Ribble Valley Borough Council
Housing & Development Control

Application no: **3/2021/0991**

Address: **4B Ashgreen House Wiswell Lane Whalley Clitheroe BB7 9AF**

Proposal: Revisions to the proposed single storey dwelling of the previously approved application (3/2020/0006), amendments include roof overhang to south facing terrace/walkway and west facing patio. Internal reconfigurations, inclusion of study, amendment to entrance lobby, additional rooflight to living room, solar panels located on the roof and inclusion of air source heat recovery system. The application boundary has been revised to exclude the existing bungalow. The proposal also includes the construction of 2 double garages.

Proposed Plan

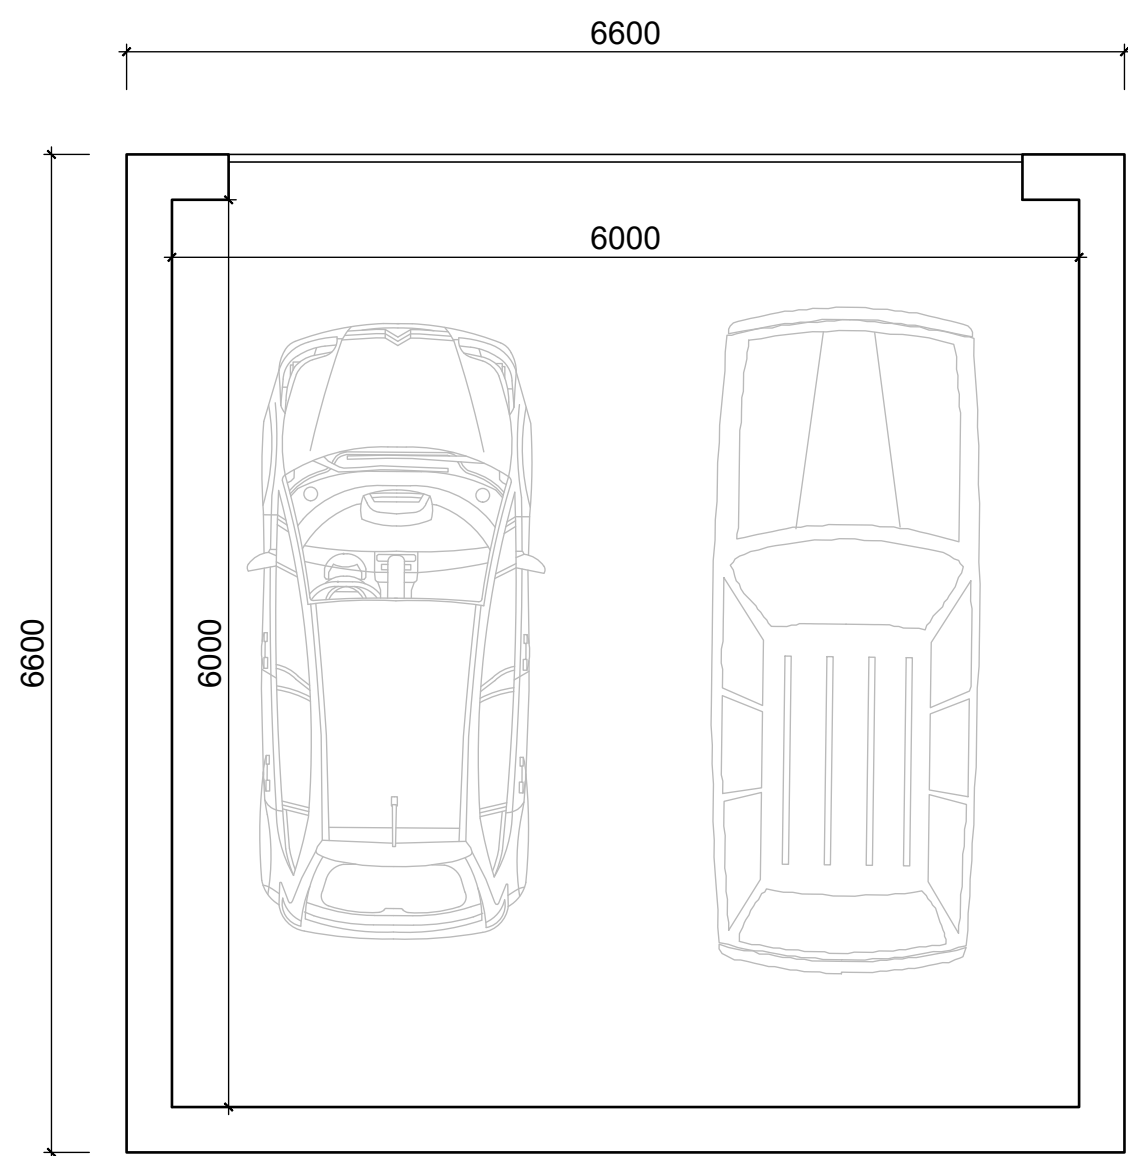
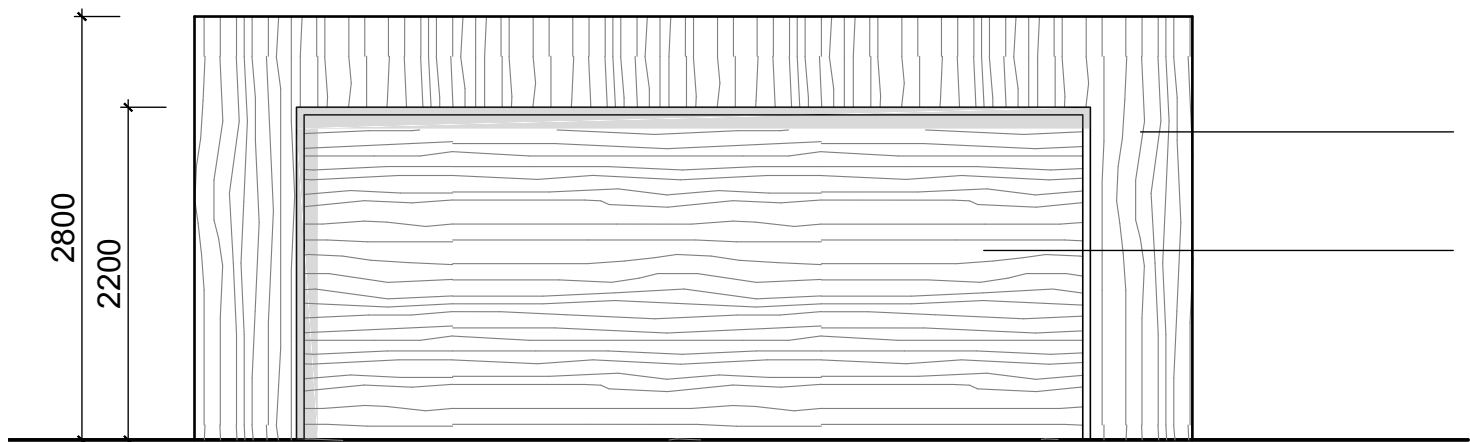
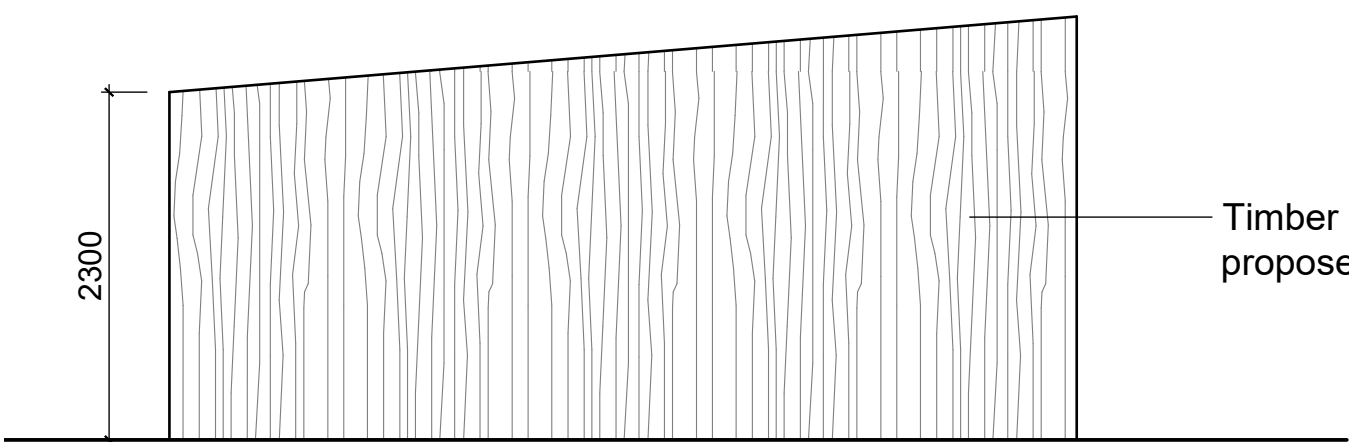
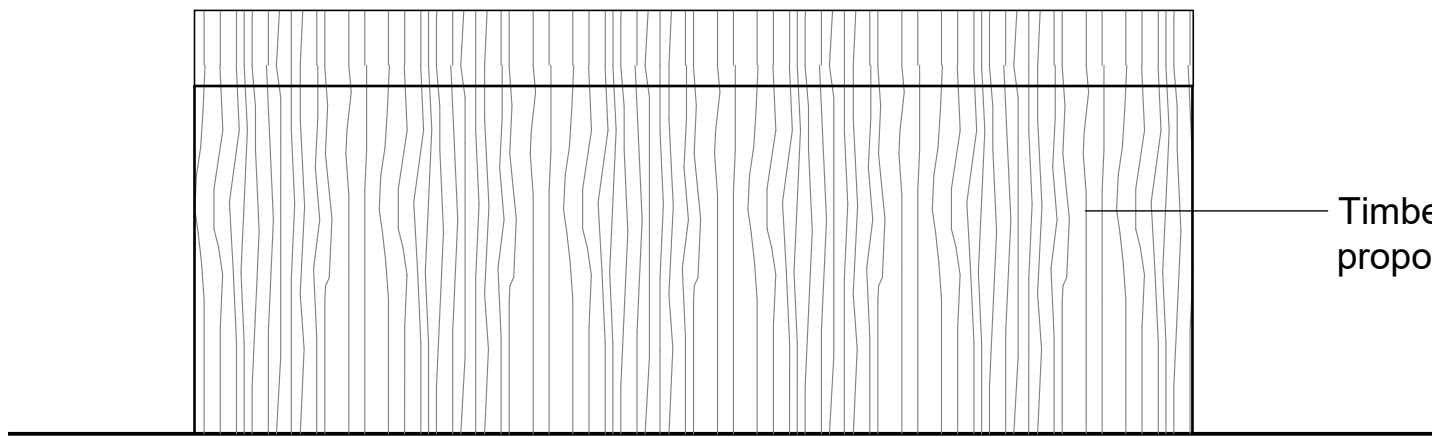
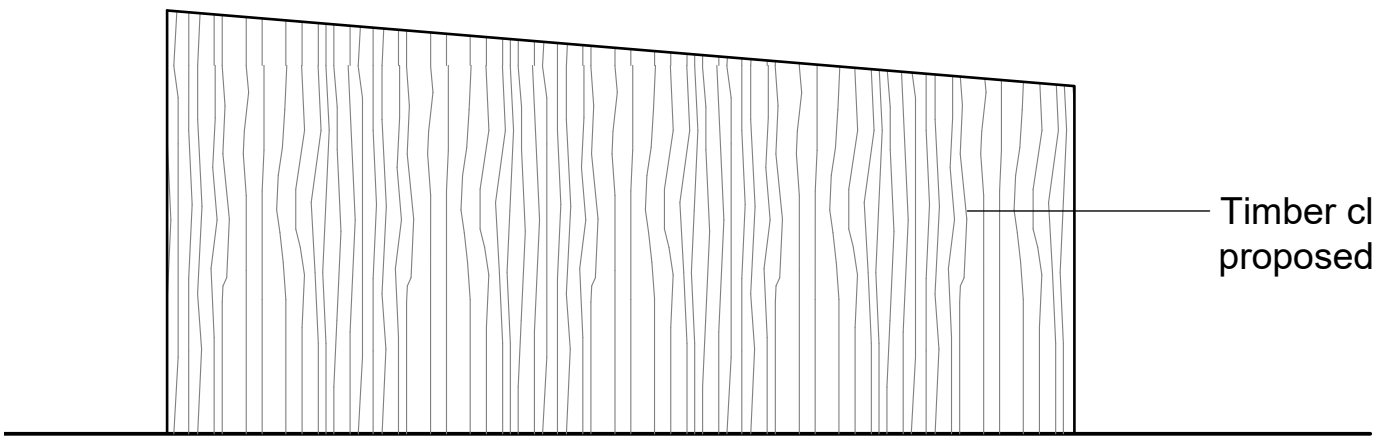
The LHA have reviewed the supporting documents and are satisfied that the dimensions of the proposed double garage complies with the LHAs guidance.
